# **HIGHWAY AND LEAD LOCAL FLOOD AUTHORITY RESPONSE TO CONSULTATION ON THE FOLLOWING DEVELOPMENT PROPOSAL**

**Application number: H08-0975-25**

**Proposal: Erection of timber framed two storey dwelling & double garage, with associated off street parking & landscaping**

**Location: Land to the North East side of Hedgefield Hurn, Gosberton, Spalding, PE11 4JE**

BLOCK PLAN.  
DWA. REF : 100/2028/2025  
SCALE : 1:500 @ A4.

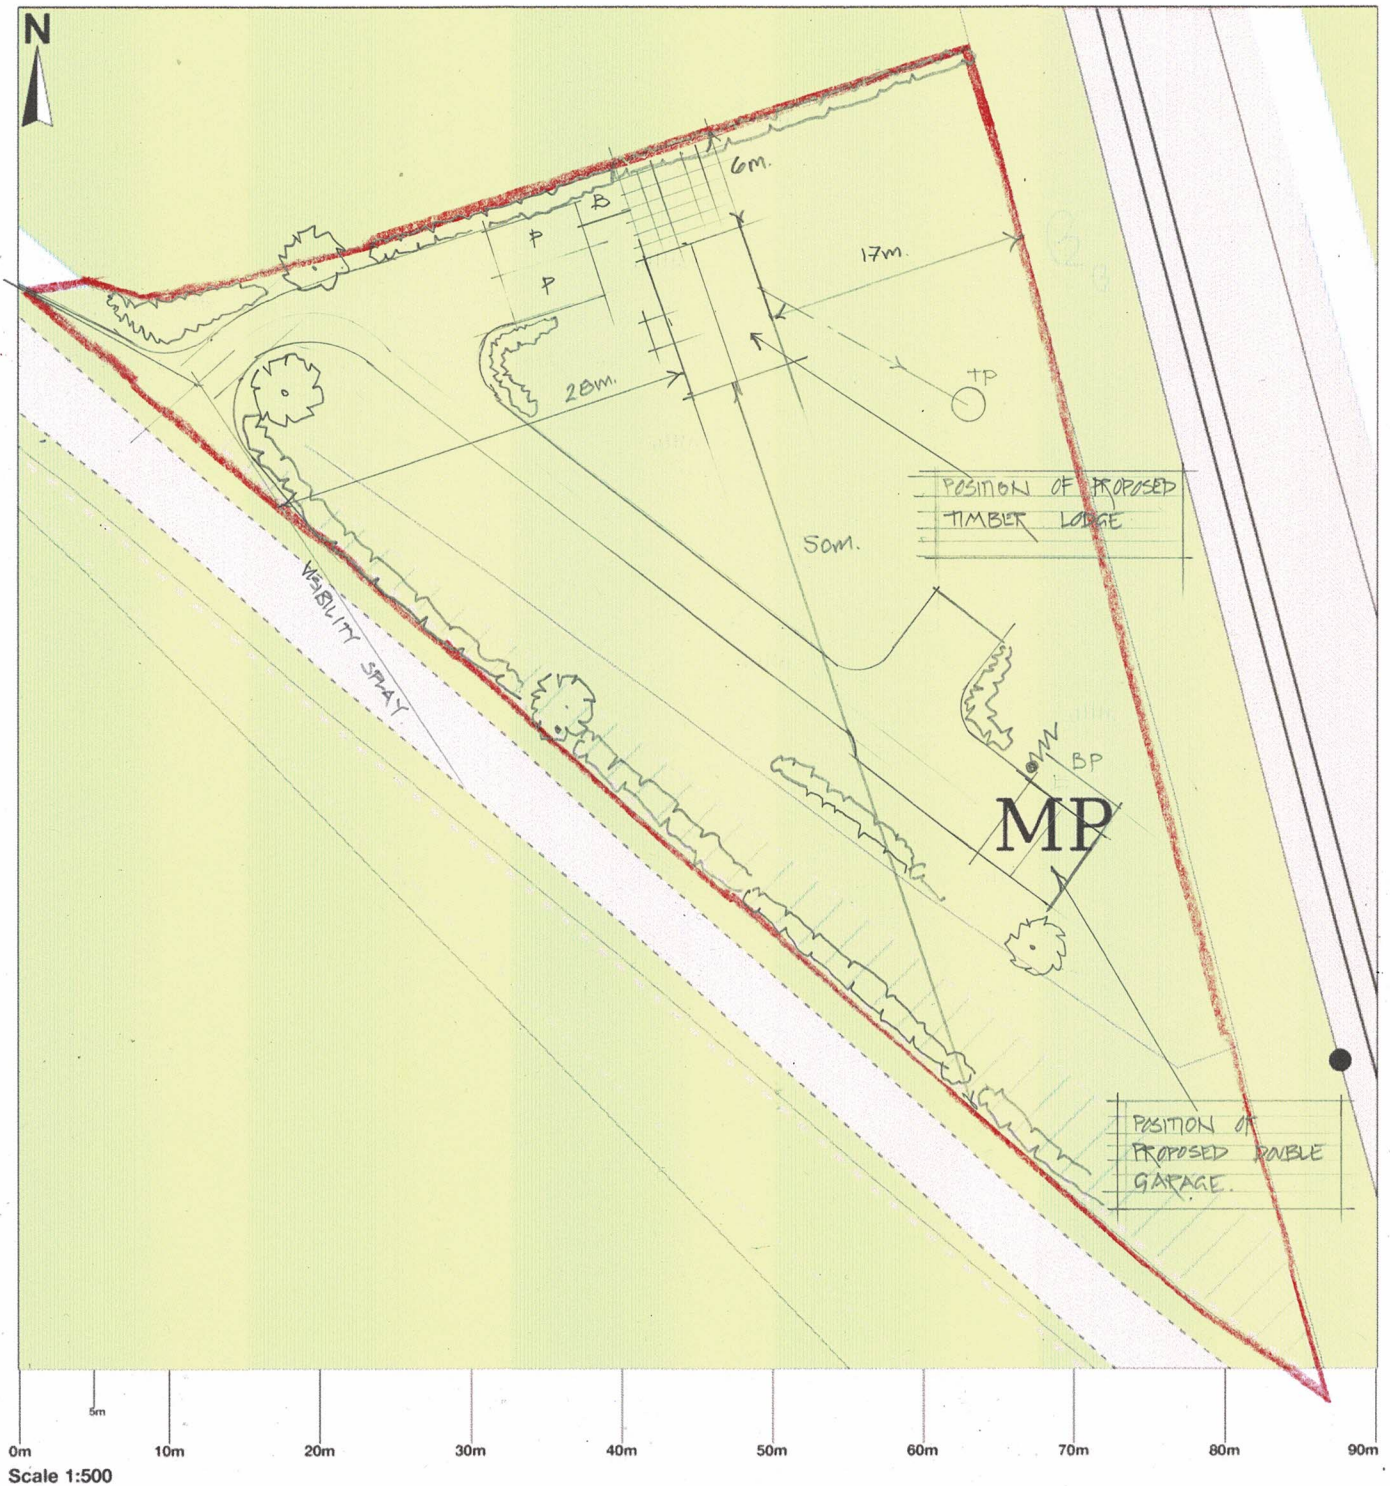
The proposal is for the erection of timber framed two storey dwelling & double garage, with associated off street parking & landscaping. The location of the access is acceptable however it will need to be upgraded to meet LCC specification. There is sufficient parking and turning demonstrated. The proposal will not have an adverse impact on the public highway.

The permitted development requires the formation of a new/amended vehicular access. These works will require approval from the Highway Authority in accordance with Section 184 of the Highways Act. Any traffic management required to undertake works within the highway will be subject to agreement. The access must be constructed in accordance with a current specification issued by the Highway Authority. Any requirement to relocate existing apparatus, underground services, or street furniture because of the installation of an access will be the responsibility, and cost, of the applicant and must be agreed prior to a vehicle access application. The application form, costs and guidance documentation can be found on the Highway Authority's website, accessible via the following link: <https://www.lincolnshire.gov.uk/licences-permits/apply-dropped-kerb>.
